**OBJECTION LETTER TO PLANNING APPLICATION – 21/04271/F**

**ON BEHALF OF THE SIBFORD ACTION GROUP**

**Erection of 6 one storey age restricted dwellings (55 years) for older people with access, landscaping and associated infrastructure - Land South of Faraday House, Woodway Road, Sibford Ferris – Blue Cedar Homes Limited**

Front (North East)

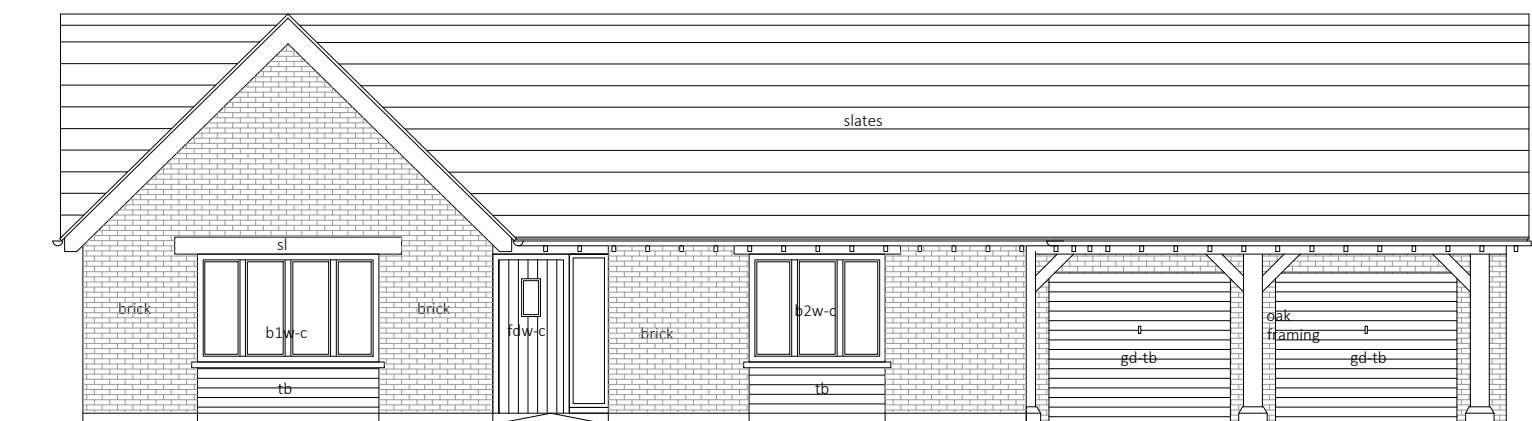
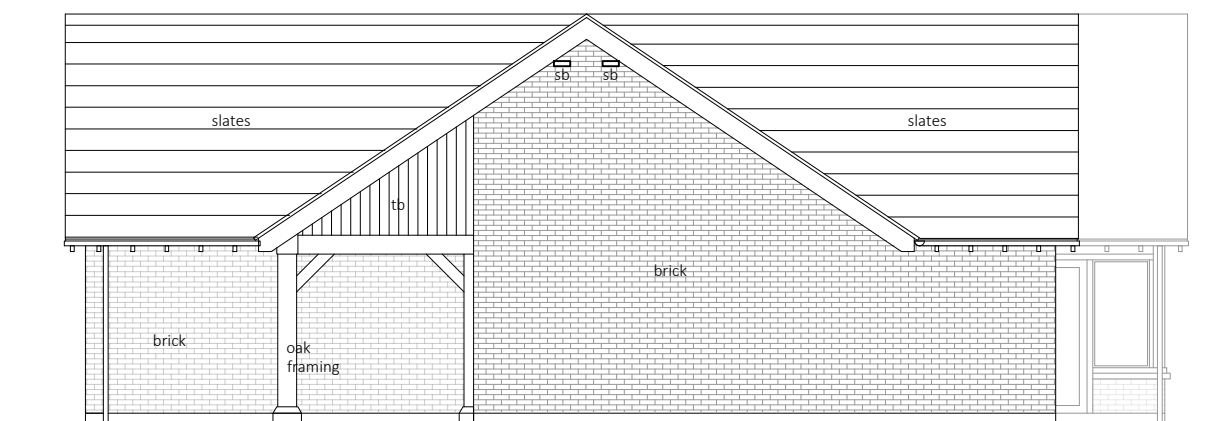
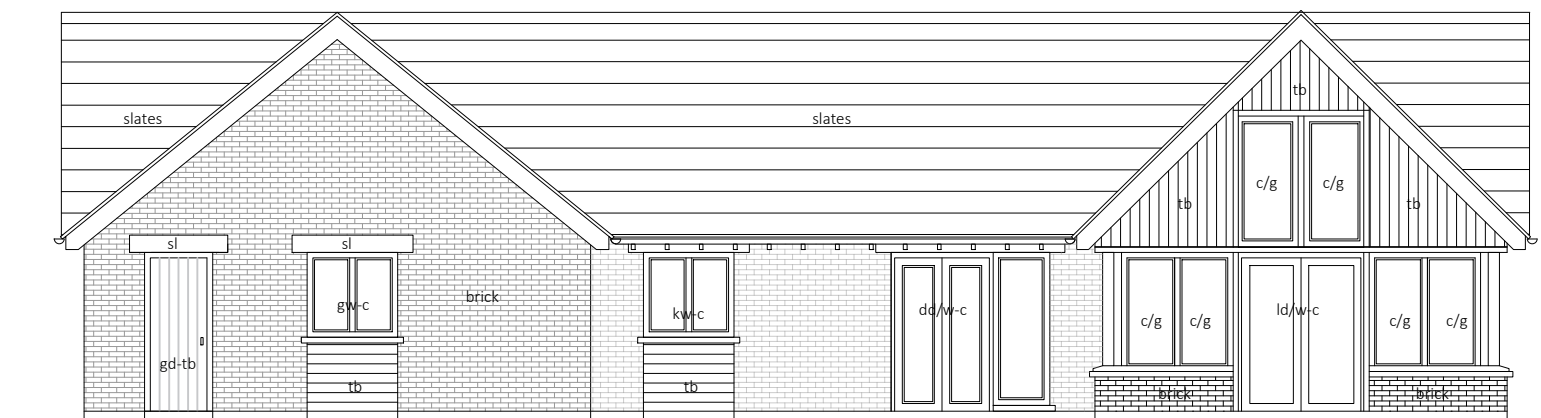
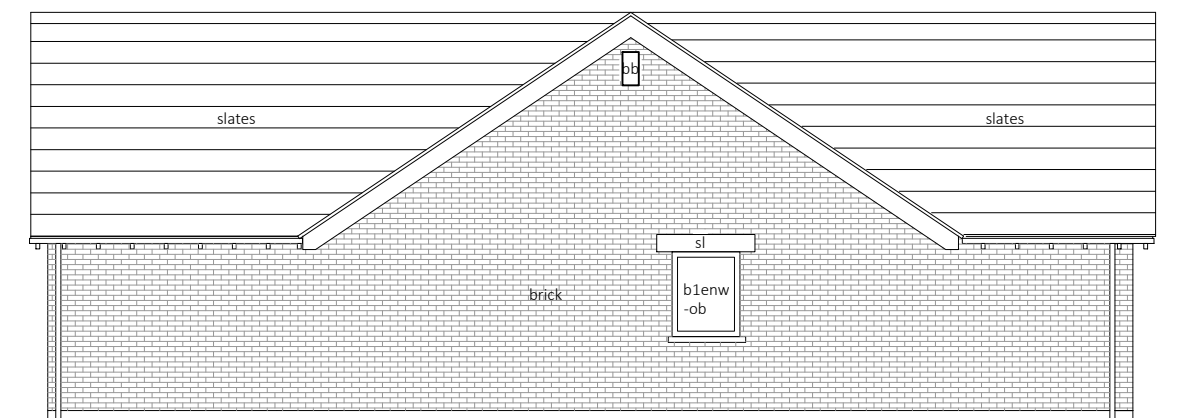
The design, incorporating large bungalows with a variety of roof pitches, timber boarding and other uncharacteristic features is contrived and takes no design cues from the established and historic character of its surroundings.
